From: Laura Gibbons
Sent: 12 December 2018 10:33
To: Michael Eastham; Fatima Evernden
Subject: LU/345/18/DOC

Attached is the proposed wording for refusal of conditions 10, 11 and 12. I have used the wording from the previous refusal for LU/88/18/DOC and used tracked changes to adjust this.

CONDITION 10 SHOULD BE REFUSED

The information submitted regarding **Condition 10** imposed on planning permission LU/47/11: relating to the submission of a fully detailed surface water drainage scheme for that phase of the development, based on sustainable drainage principles and designed in accordance with the SuDS strategy for the whole development at North Littlehampton Strategic Development Area (SDA) and the condition is not discharged as:

Figure 3.1 Existing Lagoon and Ditch (in green) to be filled in

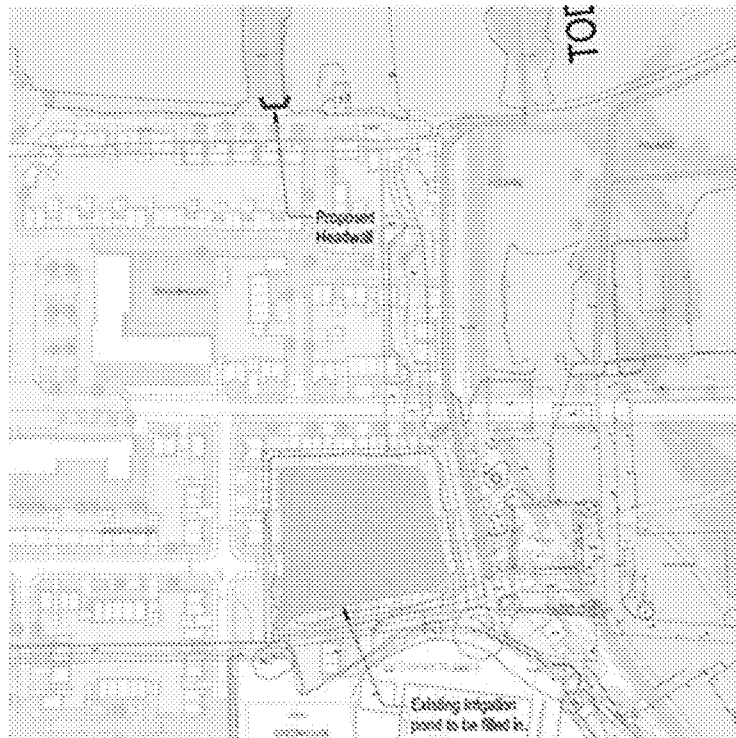
- * The proposal includes infilling an IDB ditch on site, consent will be required from the Environment Agency;
- * Detailed plans have not been submitted ensuring sufficient easement is provided to each of the ditches.

- * The proposal includes infilling an IDB ditch on site, consent will be required from the Environment Agency;
- * ~~Evidence that the Environment Agency has approved the proposed discharge rates to main river has not been submitted;~~
- * Detailed plans have not been submitted ensuring sufficient easement is provided to each of the ditches.
